CITY OF ALBUQUERQUE

Re: Volcano Heights Drainage Compilation Report, Engineer's Stamp
Dated 12-12-2011 (C10/D000)

Re: Volcano Heights Drainage Compilation Report, Engineer's Stamp
Dated 12-12-2011 (C10/D000)

Re: **Volcano Heights Drainage Compilation Report**

Drawing file: FINAL / VH PLATE 1.pdf

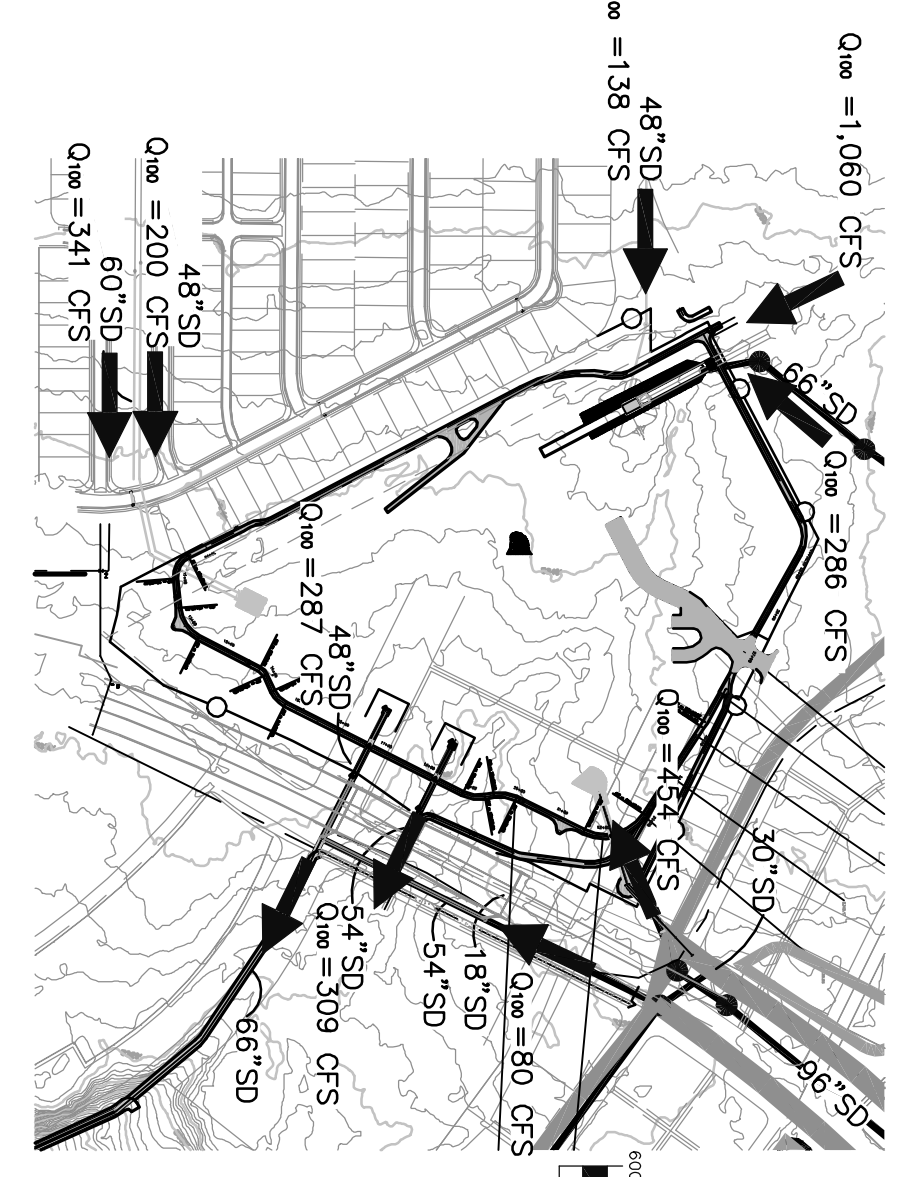
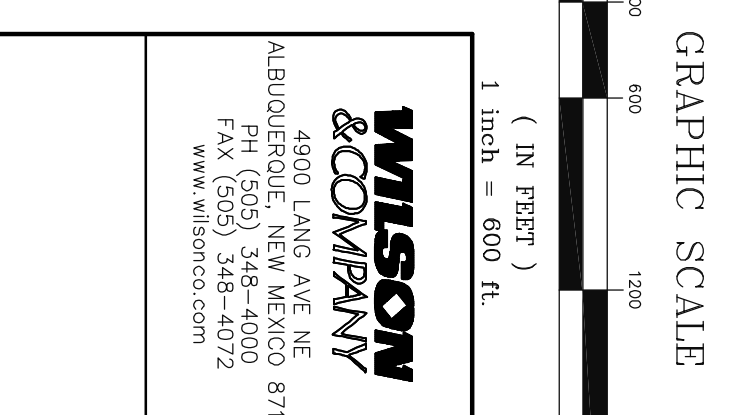
- Proposed discharge from Pond 2 is 470 cfs, and the total discharge from other Basins (4A, 4B, PDN2...) is 252 cfs. Therefore, the total discharge from these two locations is 722 cfs which exceeds the 620 cfs at AP1. The discharges from Basins 7, 12B, and A may have to be controlled discharges to meet the 620 cfs.
- Please see enclosed copy of the comments for SAD 228.

6. **Flow numbers for Basins K2, M5, M6, and T1 are not the same on the Plate-1, Table-1/Plate-1 and AHYMO calculations. T1 basin area is different from the AHYMO calculations and what is shown on the Plate-1.** All numbers corrected.
